About the application

Application number: 2024/90339	
What is the application for?:	Erection of part two storey and part single storey front, side and rear extensio
Address of the site or building:	19, Cheviot Way, Upper Hopton, Mirfield, WF14 8HW
Postcode:	WF14 8HW

PROPOSED BLOCK PLAN
1:500

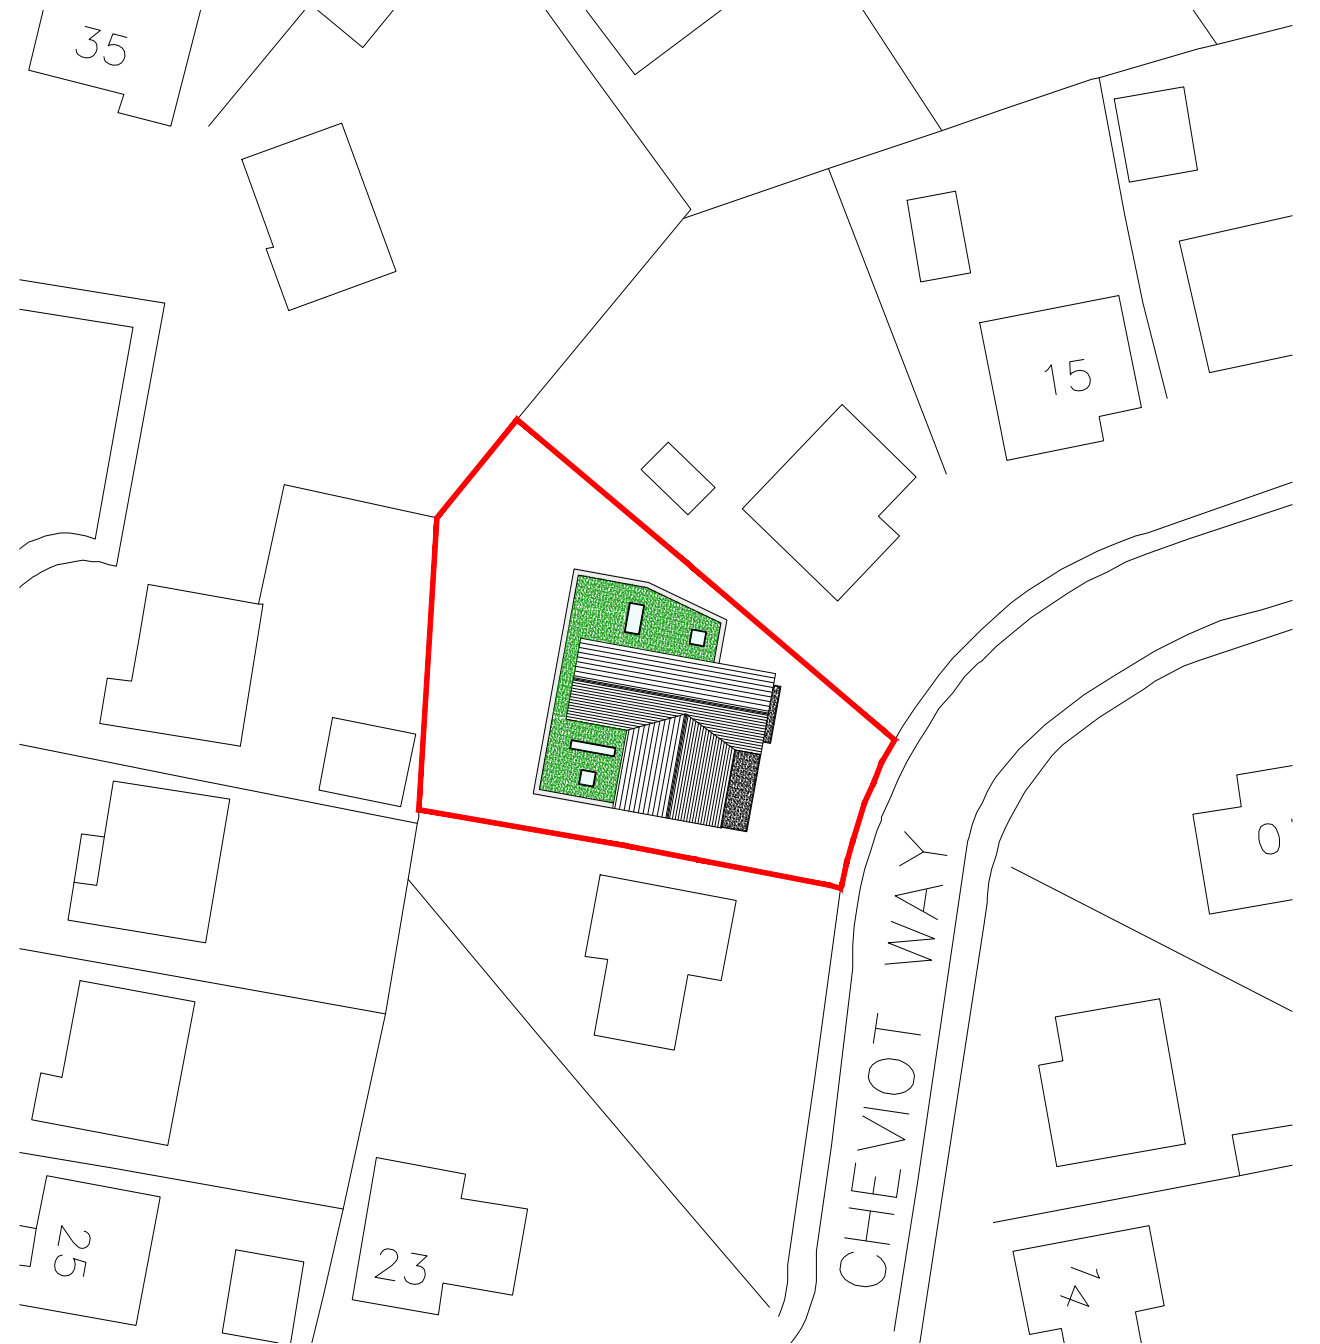
Type of comment: An objection	
Do you wish your comments to be published on the website anonymously?	Yes
We would like to express our objections to the revised application of 19 Cheviot way as follows- INCORRECT SITE PLAN The 'revised' block plan does still not include 33A Cheviot Way, one of the houses the proposed development will severely overlook. OVERDEVELOPMENT OF SITE Substantially increased size of an already large property. Over developing the site, leaving little outside space and the increased building size leaving small gap to the boarder, being out of scale with the size of the site and the design and appearance of the surrounding properties, will have a significant impact on the current character of the area and will overshadow almost all of the 6 adjoining properties. The plans do not include the floor-to-floor measurements so does not show if there is clear head room in the loft space on the plans. From the documents available it appears there is not sufficient height for the loft space without raising the roof lines. The additional loft rooms are labelled as storage / multi-use rooms with new skylights, again providing overlooking to neighbouring properties. LOSS OF PRIVACY AND OVERLOOKING Even with the reduction in the size of the balcony the number of bifold doors and additional large windows and skylight overlooking all neighbouring properties remains exactly the same, as are the proposed measurements of the property and proximity to border of other properties. Therefore no difference in our initial objection regarding loss of privacy and overlooking. There is no 'view' from the proposed balcony accept directly into neighbouring properties and bedrooms therefore we feel this a massive invasion of privacy. Our are at the back and the balcony will overlook both as well as our and the of

our property which is beyond acceptable limits and resulting in significant loss of amenity and privacy.
